Application No: EP/14/21/HH
Site Address: 38 The Roystons East Preston BN16 2TS
Description of works: Single storey side and rear extensions and conversion of roofspace to habitable use

Thank you for your internet representation made on 12th February 2021 which has been recorded as an objection with the comments as follows:

Proposed rear elevation

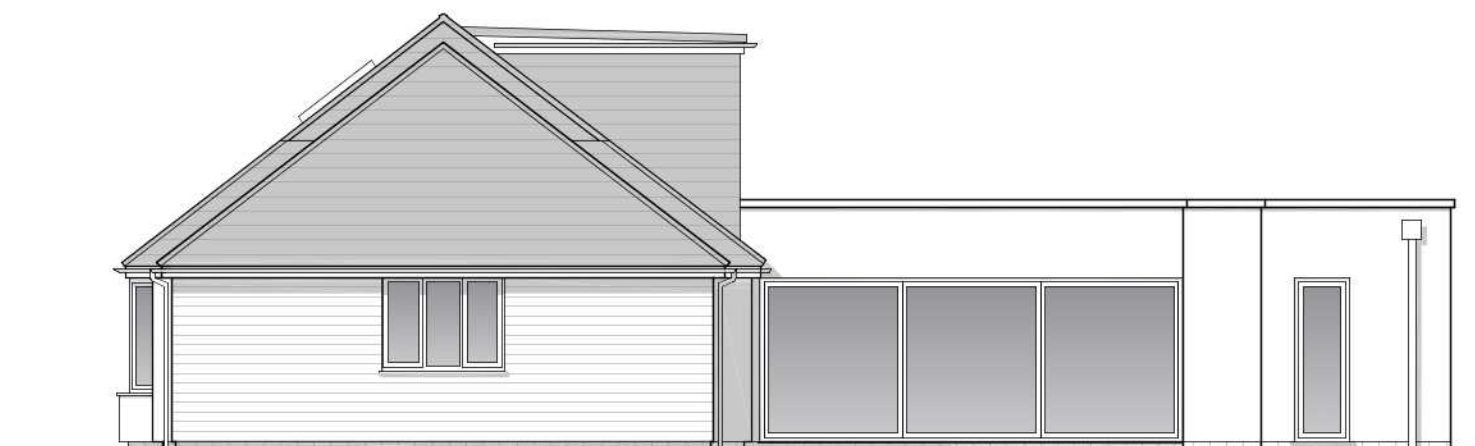
Having looked at the proposed plan (rear elevation) for EP/14/21/HH which is 38 The Roystons we at 42, The Roystons object in the strongest possible terms.

These dormer windows will look directly into our rear living room and all our back garden completely invading and destroying our privacy.
